From: Stephen Leech [REDACTED]
Sent: 28 August 2015 14:18
To: Ross Leal
Subject: Planning Application AW/208/15/HH

I've taken your advice and detailed below the reason for our objection to the proposed extension at 11 Waters Edge, Aldwick.

Proposed Elevations and
Perspectives

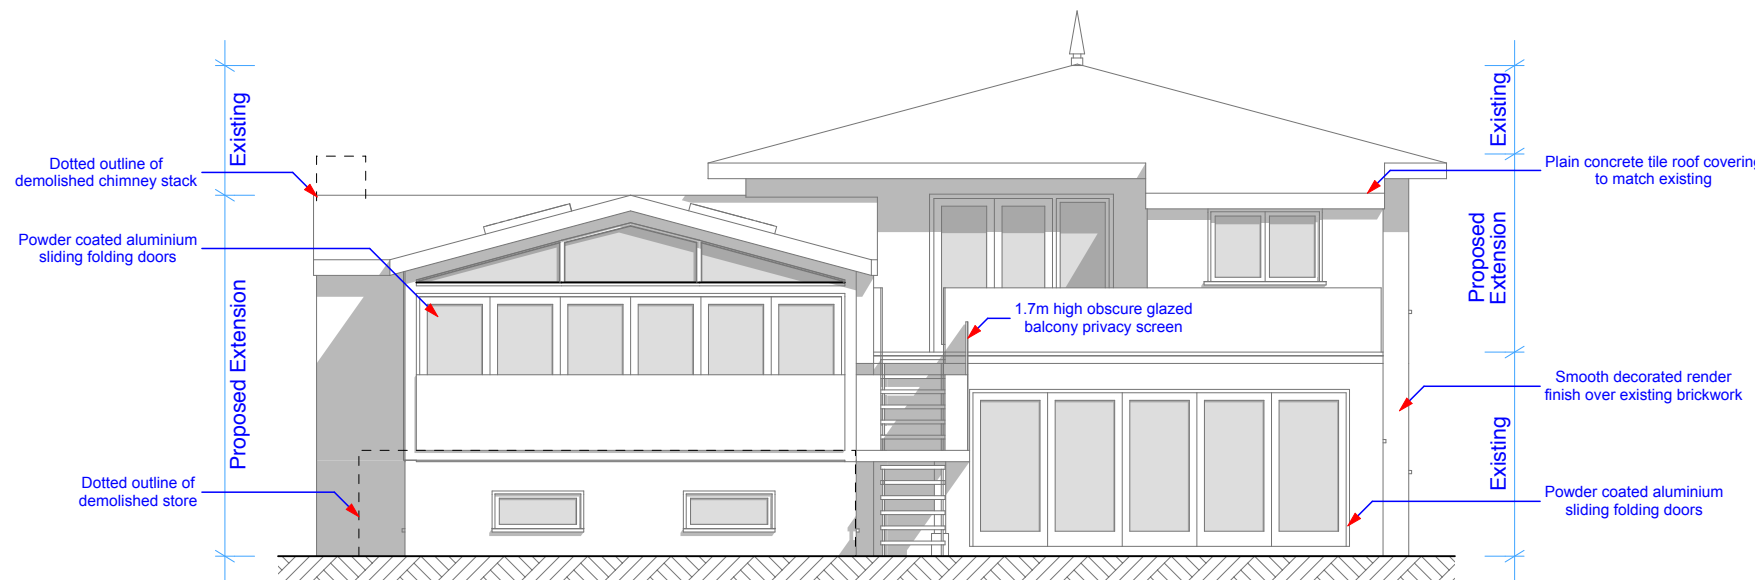
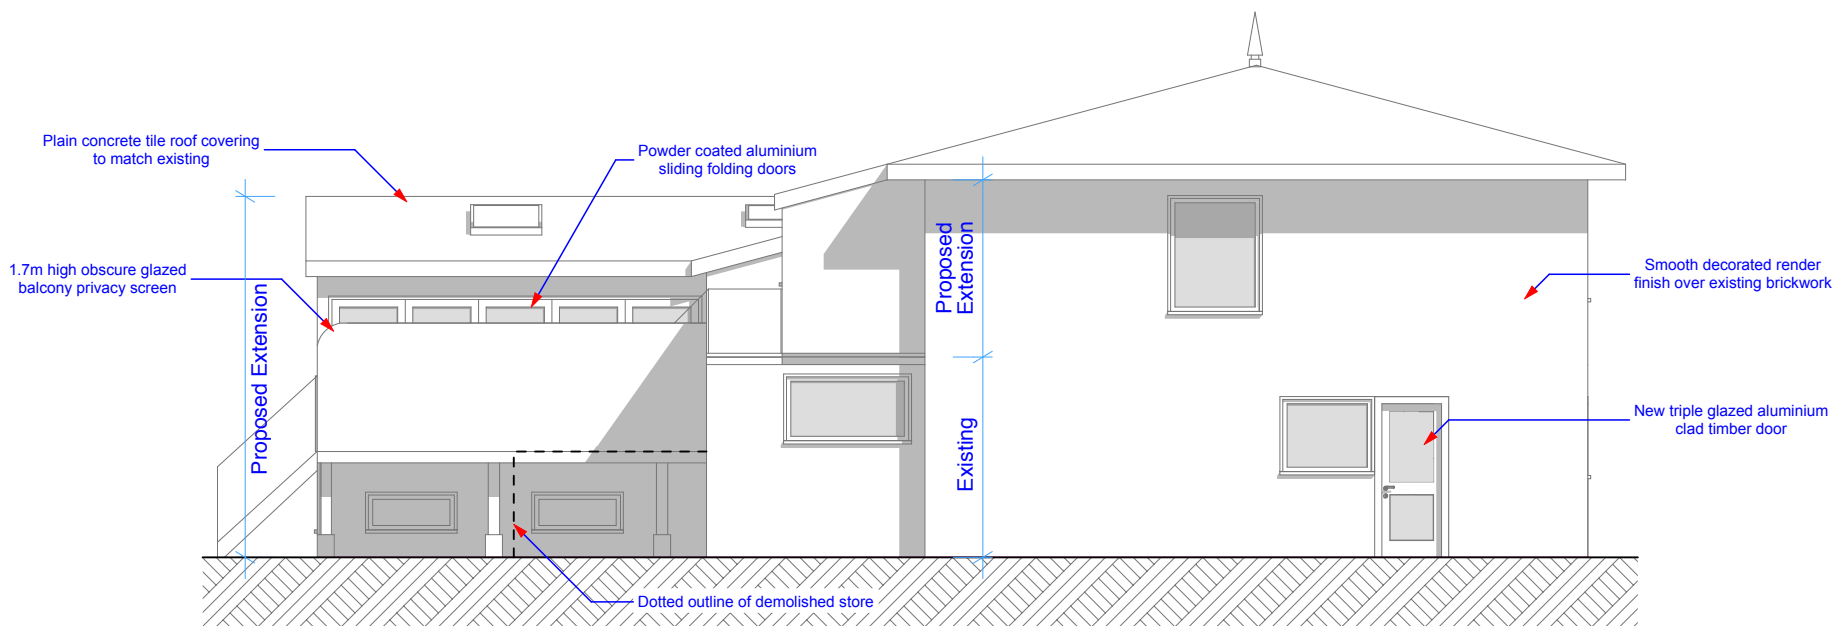
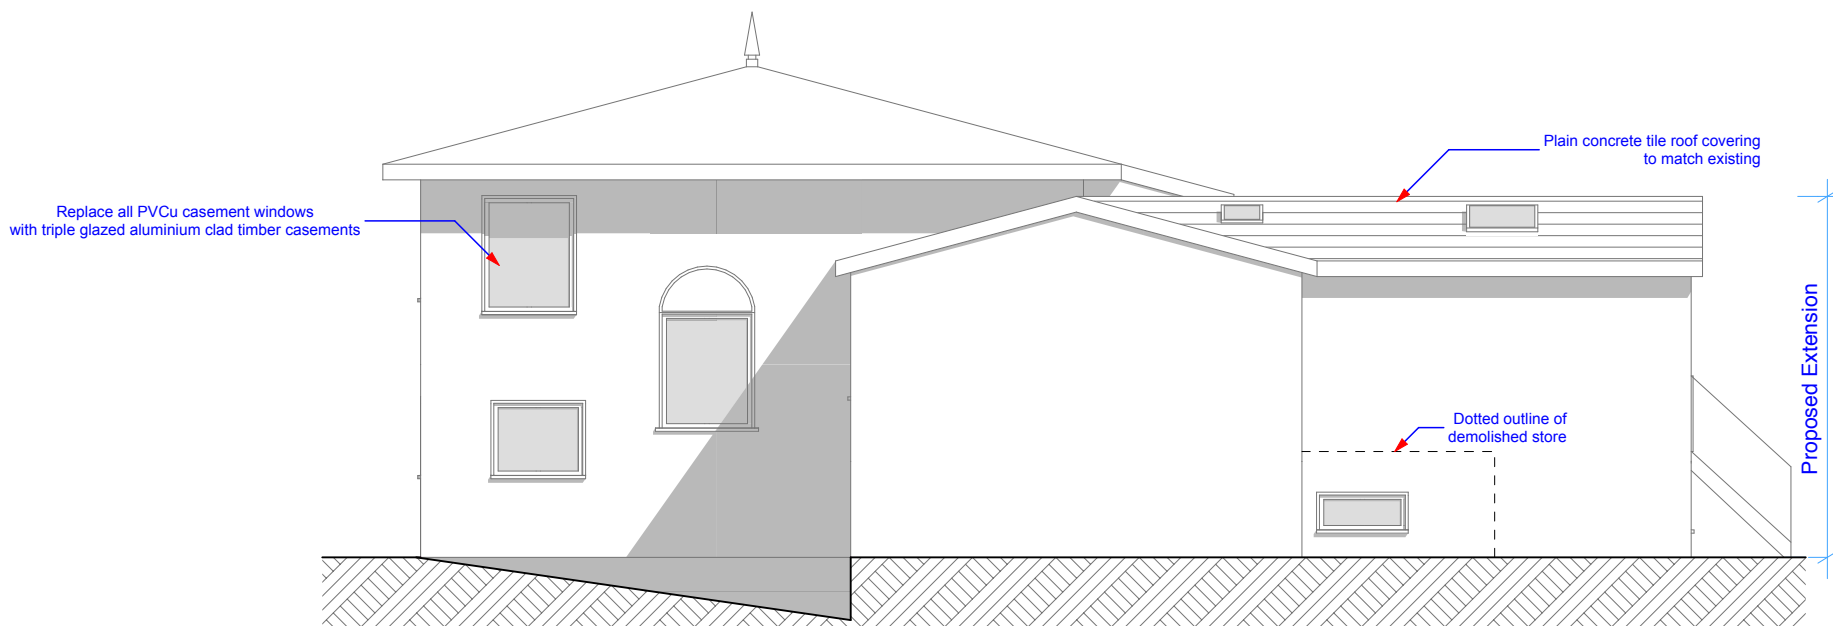
We strongly object to the extension on the grounds that it will intrude on our privacy given that the side elevation of the 2 story extension has a proposed fully glazed side elevation that overlooks into our main bedroom. With also a corresponding view that we will have directly into their living room. As you can see from the attached photograph, our house sits lower than our neighbours hence this view.
